Final Report - Corrections Required Application No. ANEX-23-0014

Description : A request by Norris Ranch Joint Venture, LLC, for annexation of 19.605 acres into the City of Colorado Springs. The annexation is a part of the overall Karman Line Land Use Plan, which is being submitted concurrently. The Land Use Plan proposes a maximum of 6,500 dwelling units, approximately 45 acres of light industrial, 105 acres of commercial/retail, 100 acres of mixed-use development, and 570 acres of park/open space.

Document Filename : Annexation Plat_Rev

SHEET 3-1

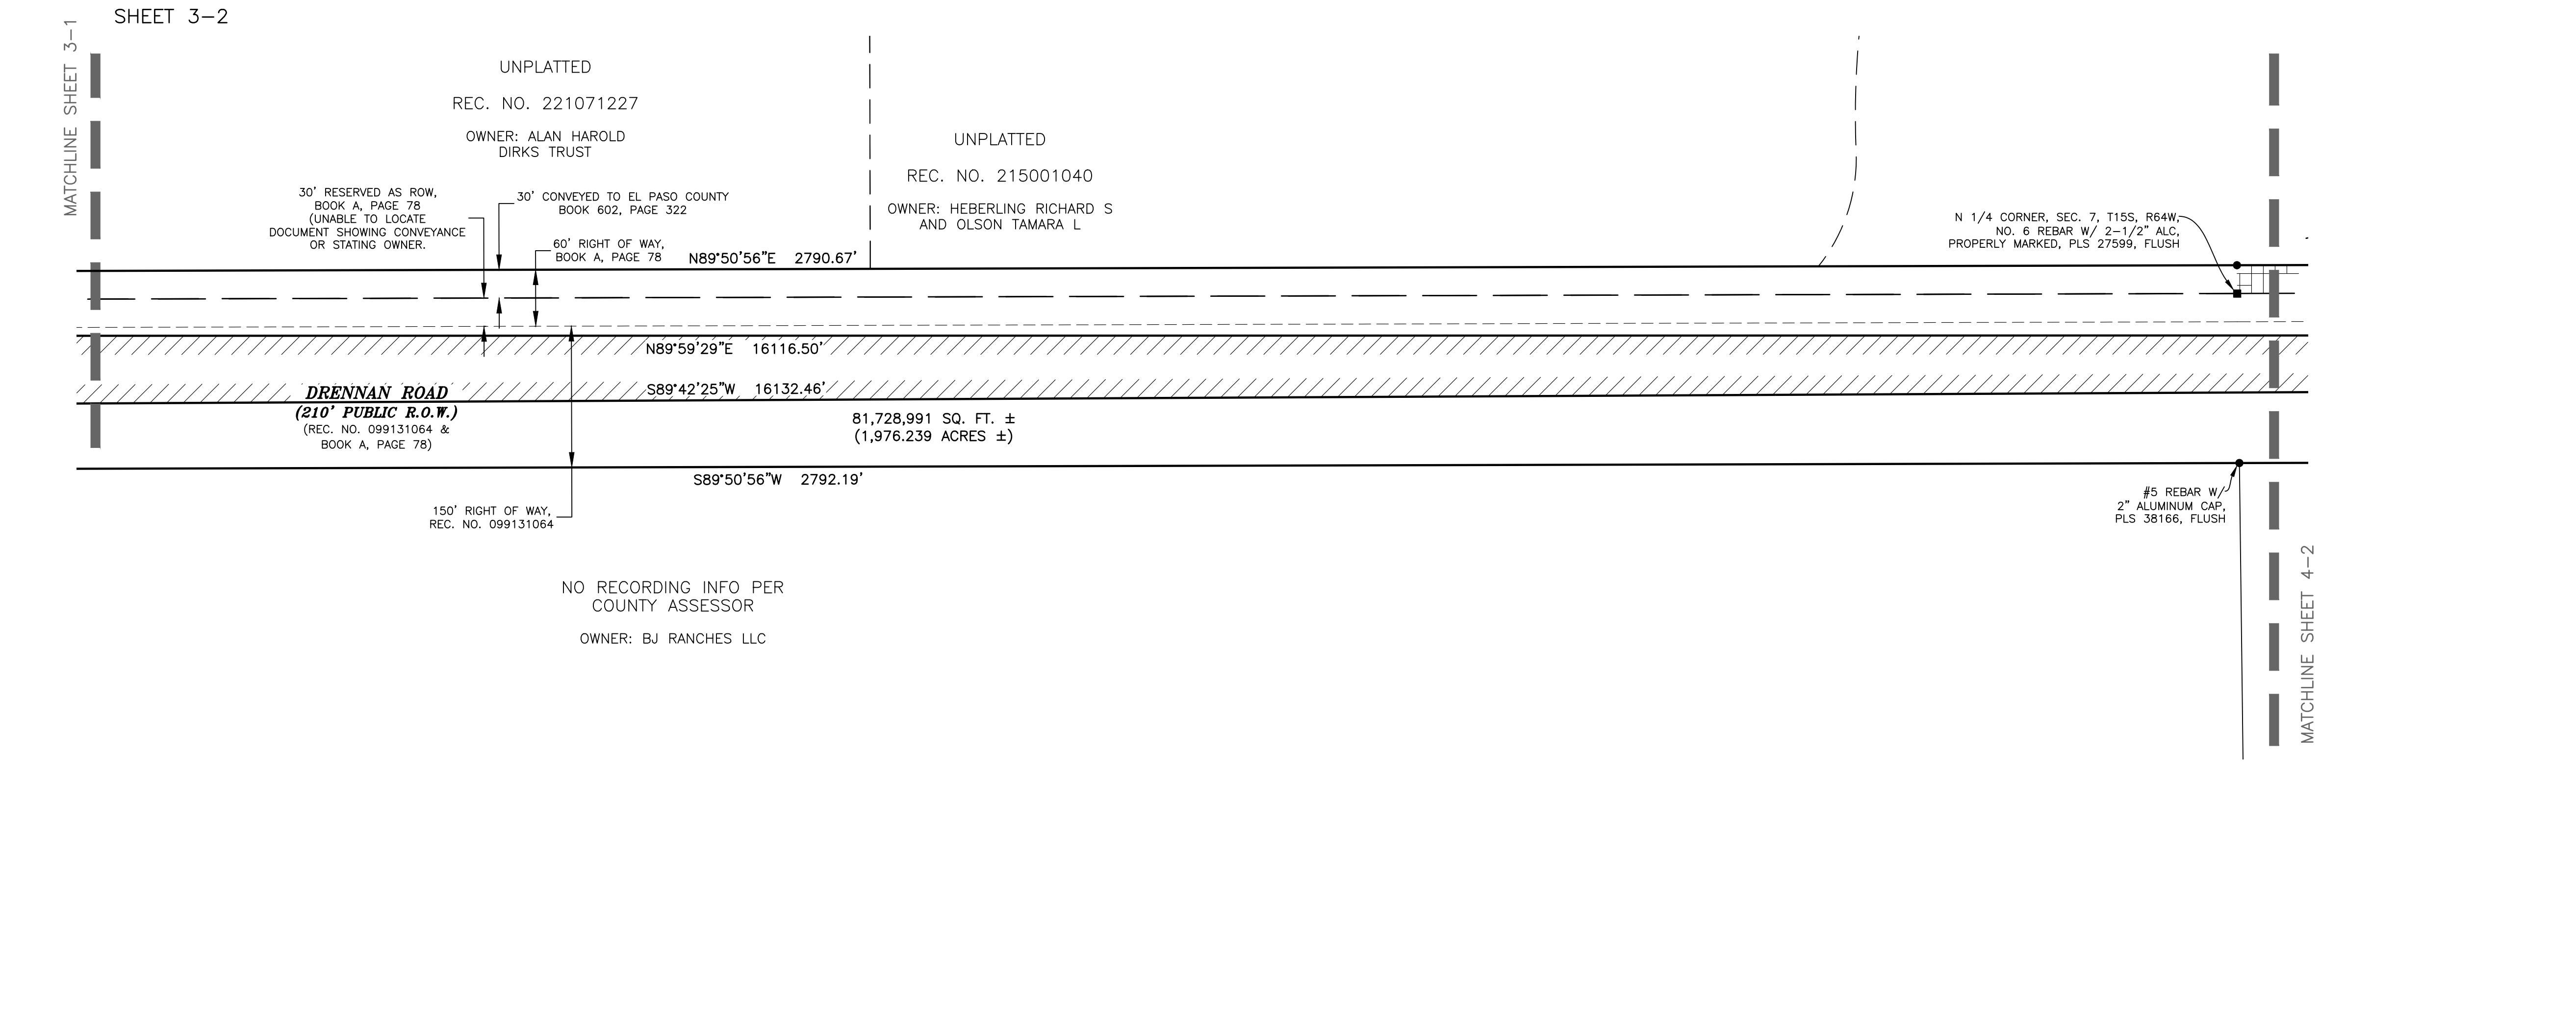
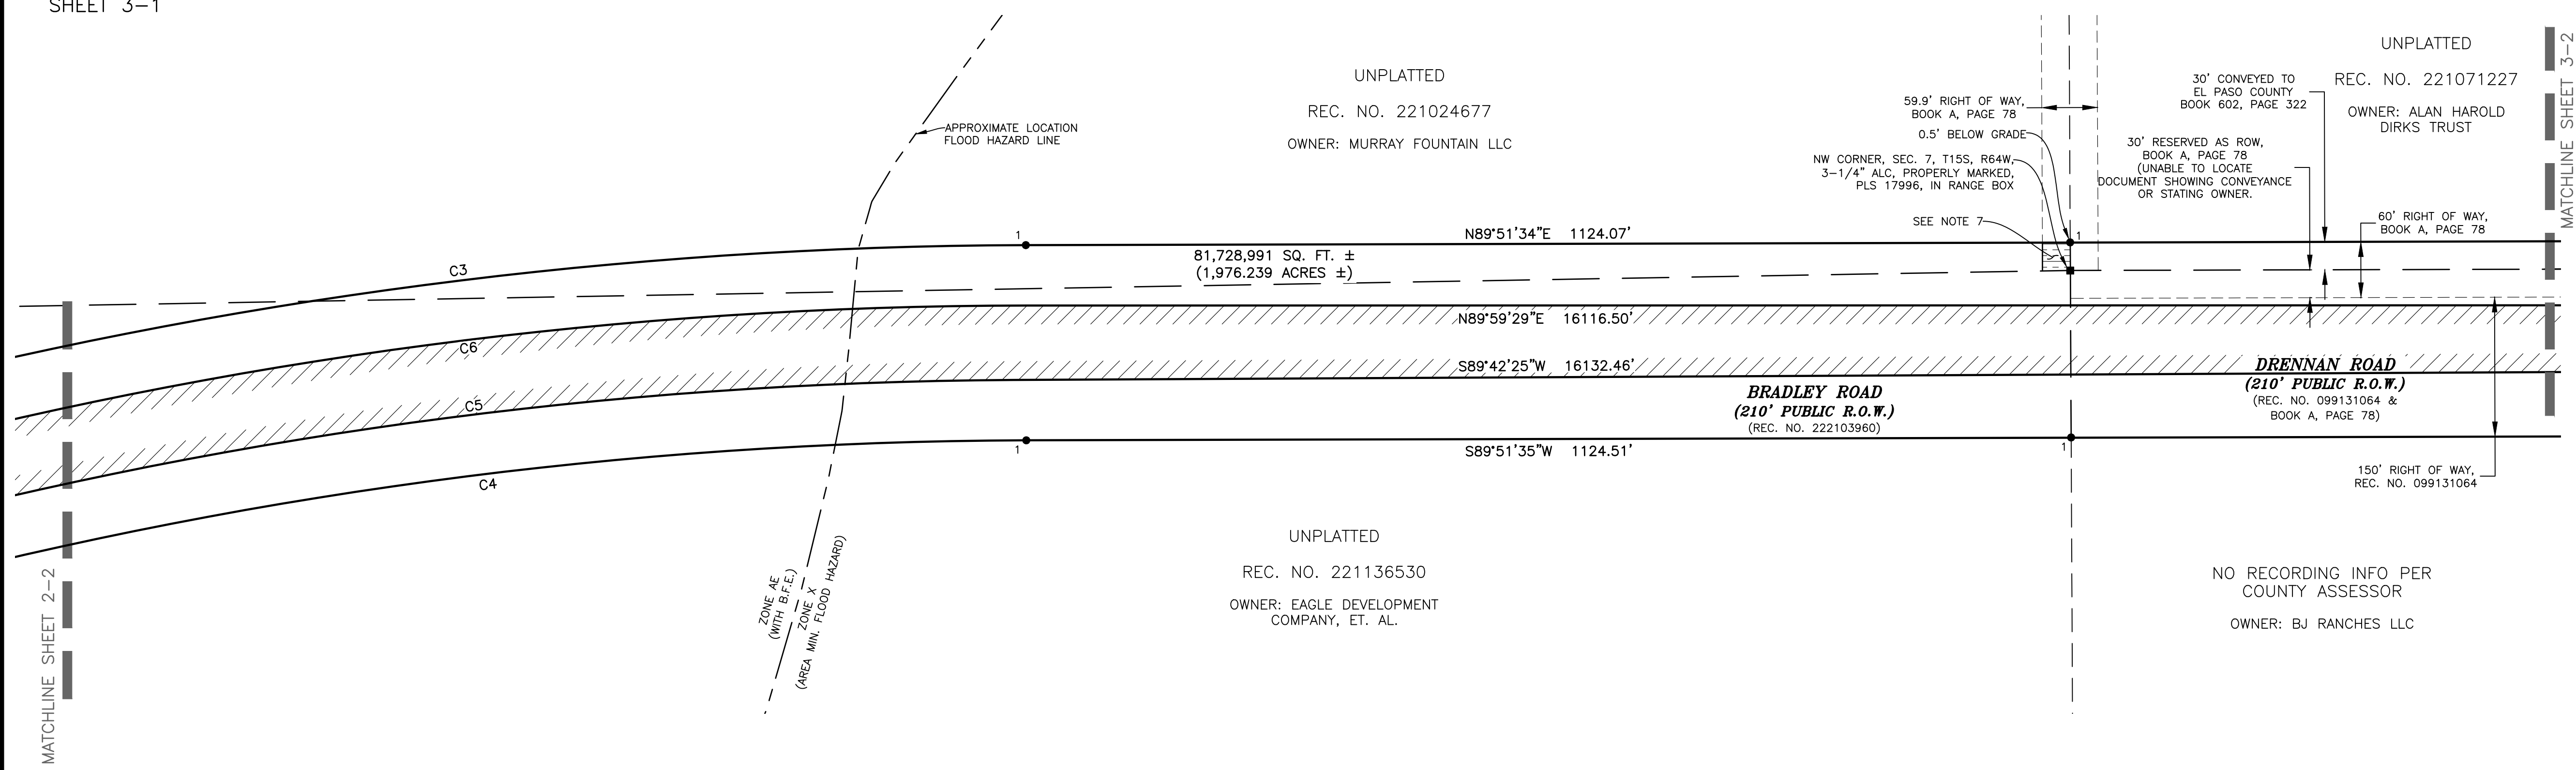
-	3	Cory Sharp : Planning	
-	3	Cory Sharp : Planning	
59	3	Cory Sharp : Planning	Sheet 3 of 5
67	3	Cory Sharp : Planning	? still applicable
68	3	Cory Sharp : Planning	Please check/revise the location of the termination of Bradley Road recorded under reception no. 222103960 which terminates at the east line of the northwest quarter of section 7, which appears to be approximately 2640' further east. Please revise accordingly
69	3	Cory Sharp : Planning	Please check/revise should this be a 60.00' right-of-way
70	3	Cory Sharp : Planning	Is this Drennan Road? Please add appropriate label
71	3	Cory Sharp : Planning	Bradley Road reception no. 222103960?
72	3	Cory Sharp : Planning	Is this location the termination of quitclaim deed reception no. 222103960?
73	3	Cory Sharp : Planning	Please add the calls to the terminus of the quitclaim deed within the legal description

SHEET 4-1

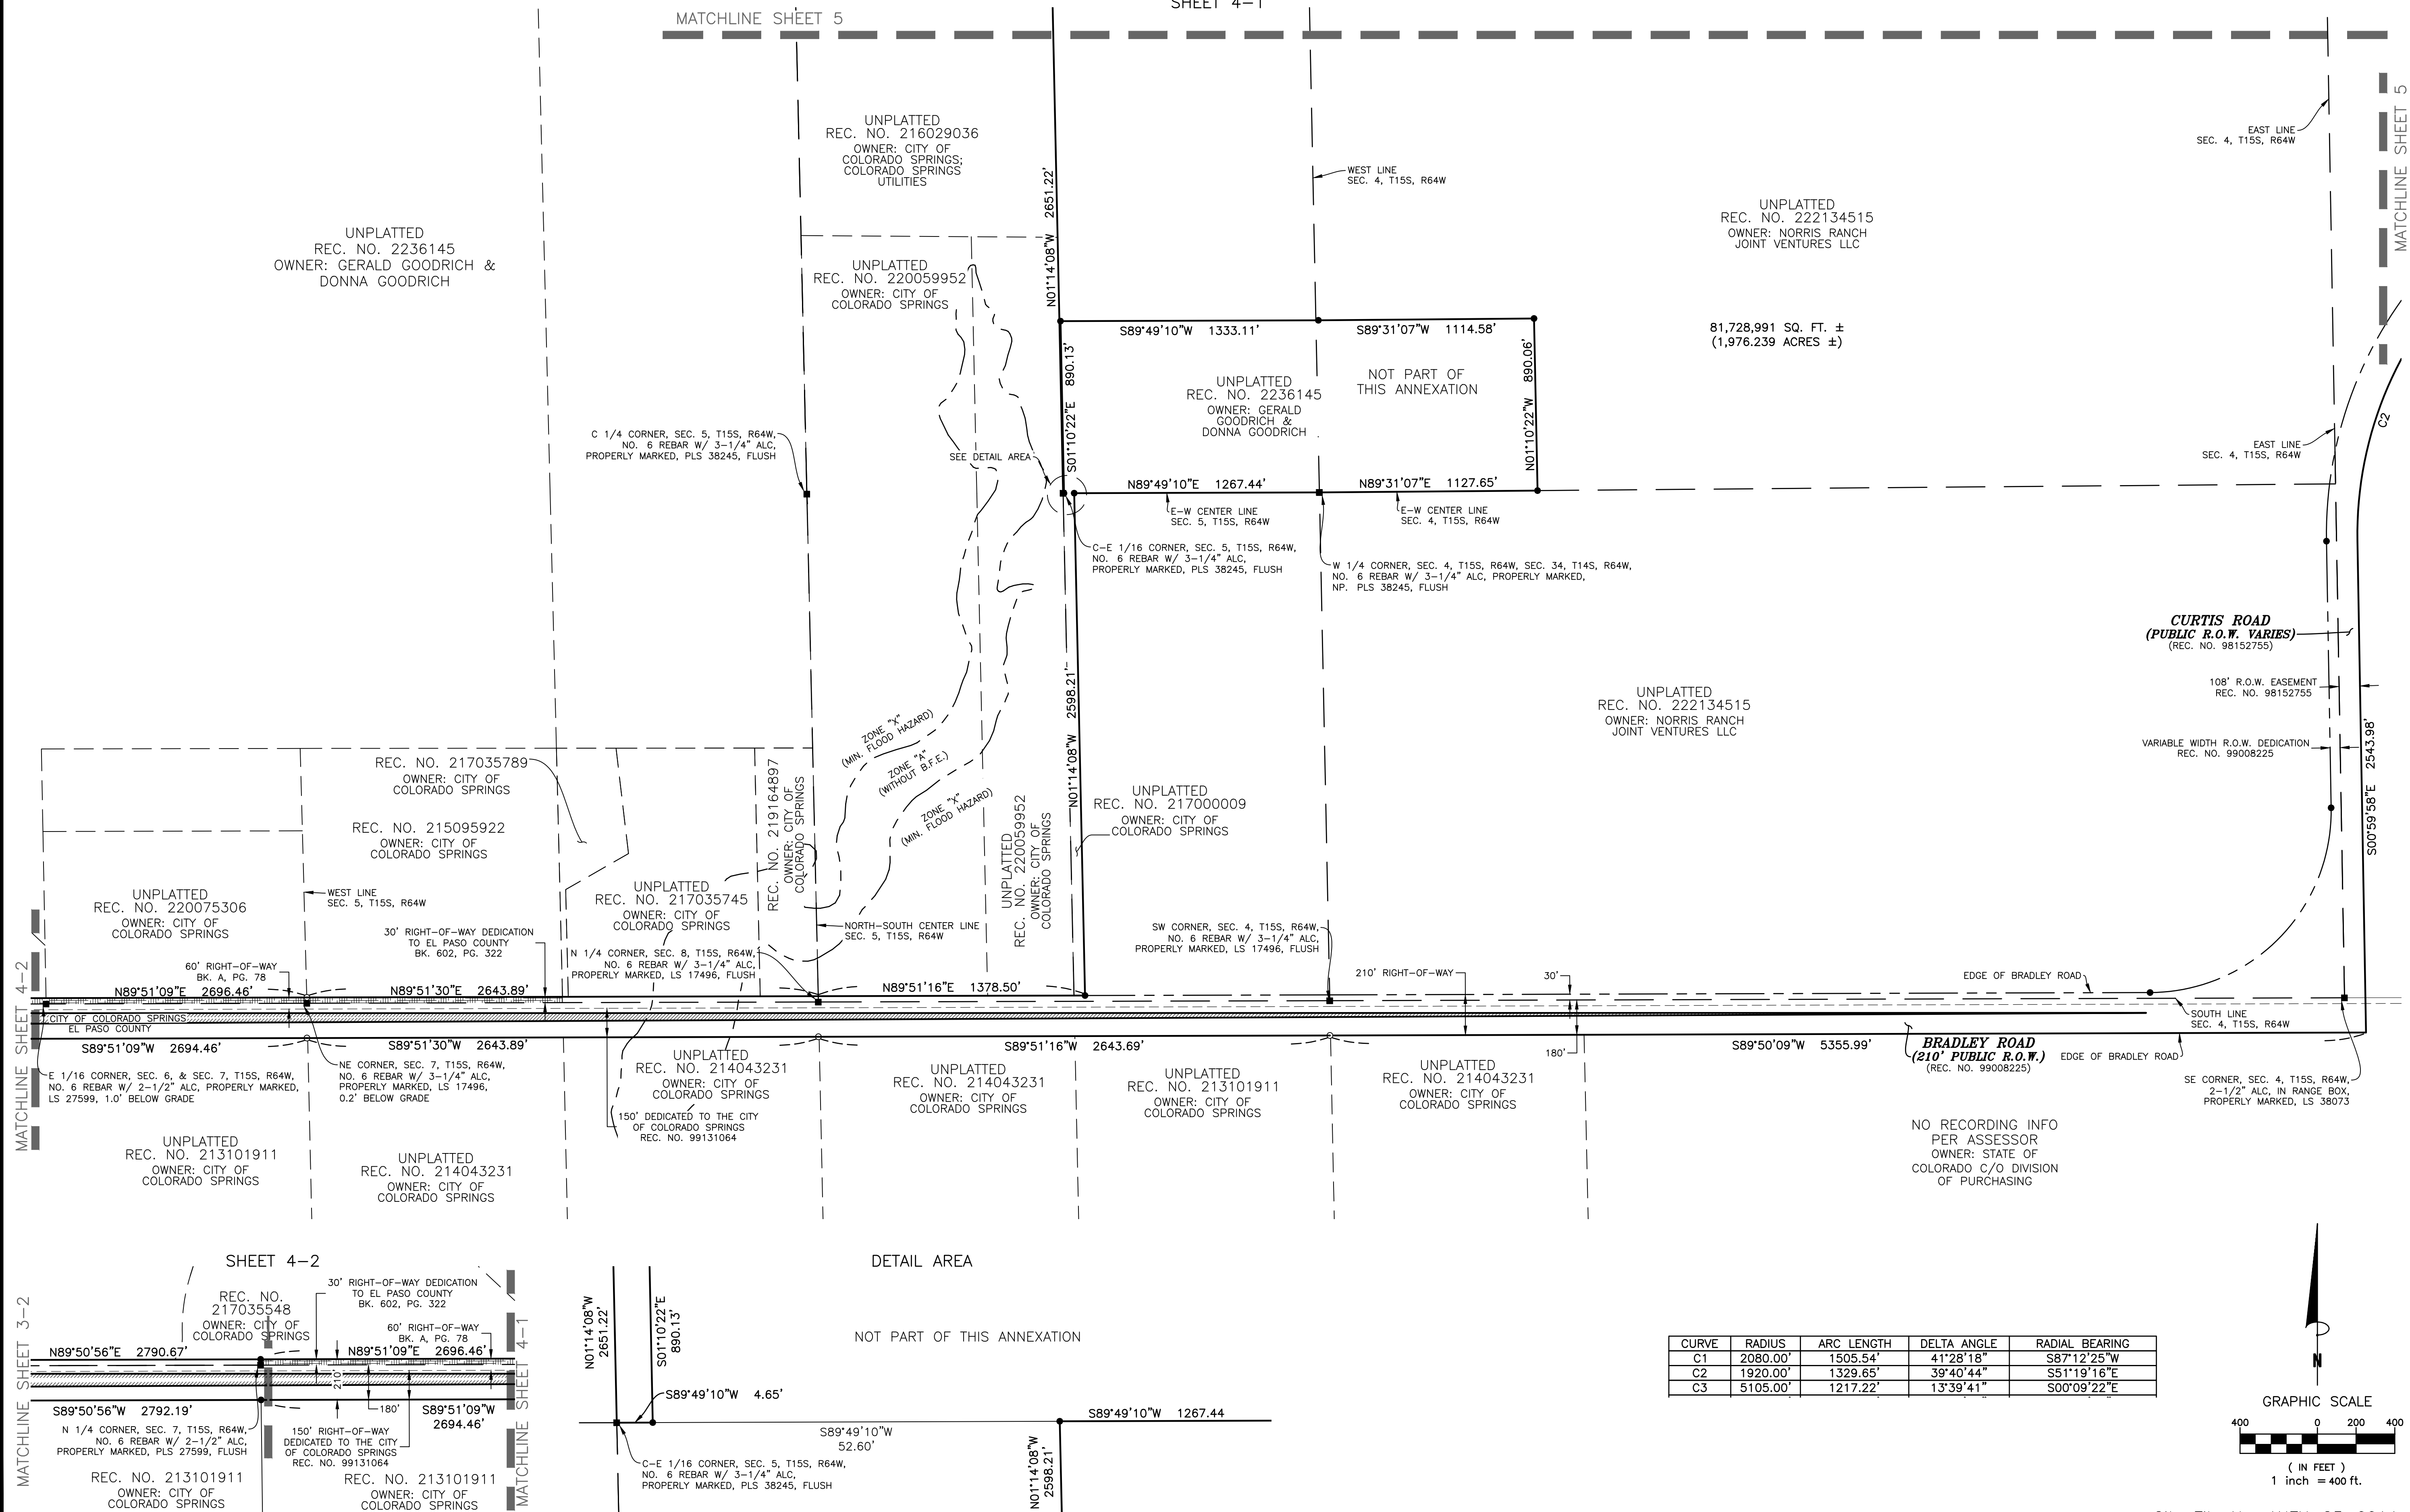
-	4	Cory Sharp : Planning	
60	4	Cory Sharp : Planning	Sheet 4 of 5
74	4	Cory Sharp : Planning	There appears to be dirt access to the Goodrich property in this approximate location, does there need to be a defined access easement?
80	4	Dan Sexton : Planning	For all segments of roadway to be annexed , please provide legal descriptions for the roadway segments so they can be conveyed from El Paso County to COS prior to annexation.
61	5	Cory Sharp : Planning	Sheet 5 of 5
75	5	Cory Sharp : Planning	Please add the distance 2651.22' from the adjacent sheet along this line
76	5	Cory Sharp : Planning	Please depict the continuation of Curtis Road north of this area
77	5	Cory Sharp : Planning	Please depict and label the roadway going to the east
